## **Necton Parish Council (EN010079) Response to Additional Vanguard Questions**

### **Additional Questions, Paragraph 18**

Figure: 29.24a	Drawing No: PB4476-004-029-024				
Revision:	Date:	Drawn:	Checked:	Size:	Scale:
04	15/05/2018	LA	JP	A3	Multiple
05	04/06/2018	LA	JP	A3	Multiple

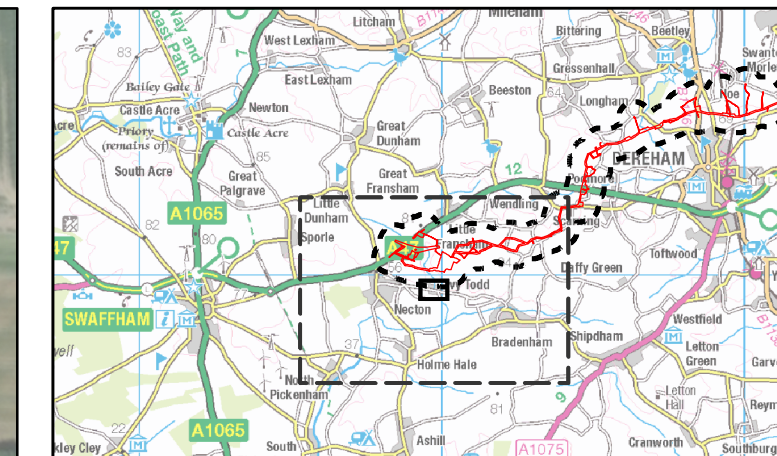
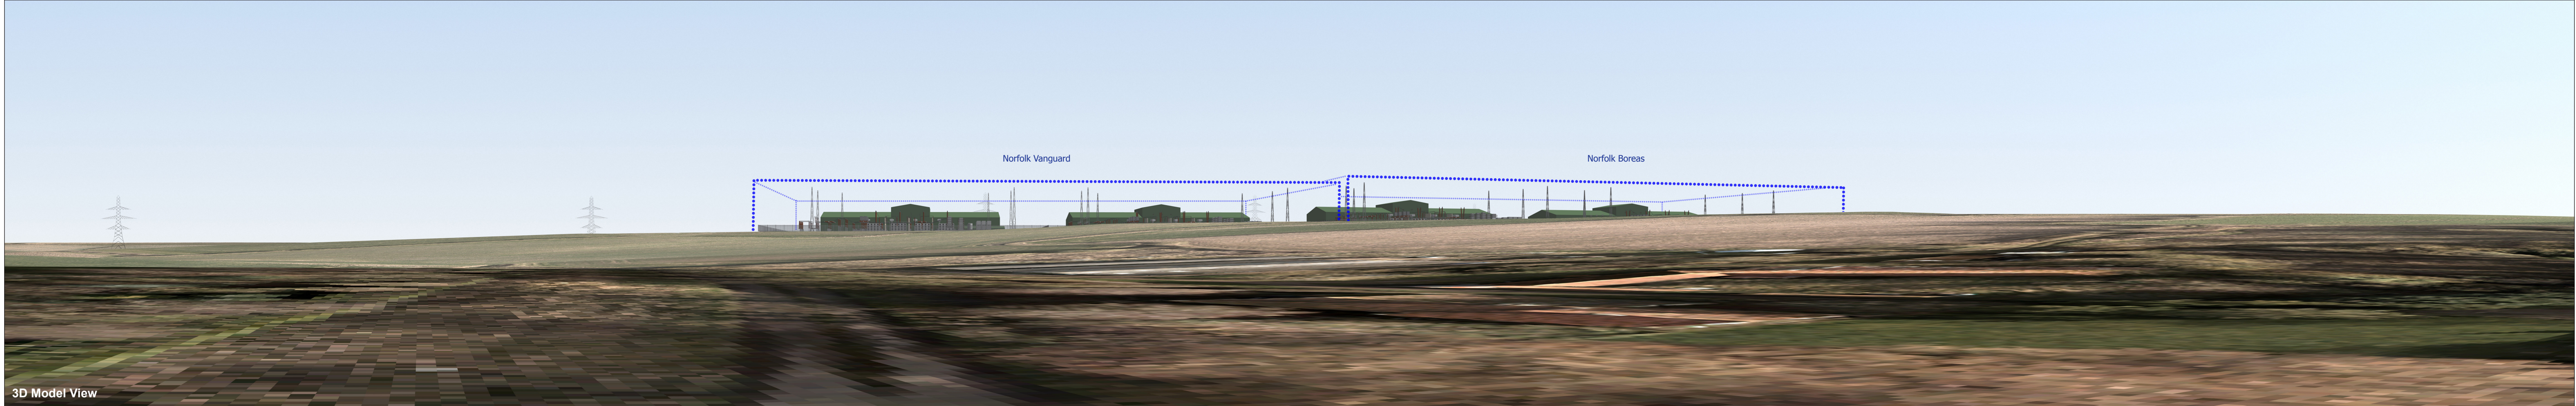
We also ask that this amendment be taken further to include the height of the converter halls. We ask that the following requirement be added:

“The converter halls must be lowered into the ground such that they do not exceed a height of 15 metres above existing ground level.” Also: “The soil removed must be re-used to build 15-metre-high earth banks around the outside of the converter hall site. The earth banks must be planted with trees.”

This requirement should entirely mitigate the views of these massive buildings and the masts on their roofs (25 metres height in total) from Necton and Ivy Todd over time. We have made the same request to the Boreas Examination panel and it would make sense to have the same requirement for both projects since the buildings will be adjacent. The use of earth banks 15 metres high is already nearby along the Northern Distributer road so is in keeping with the local planning requirements.
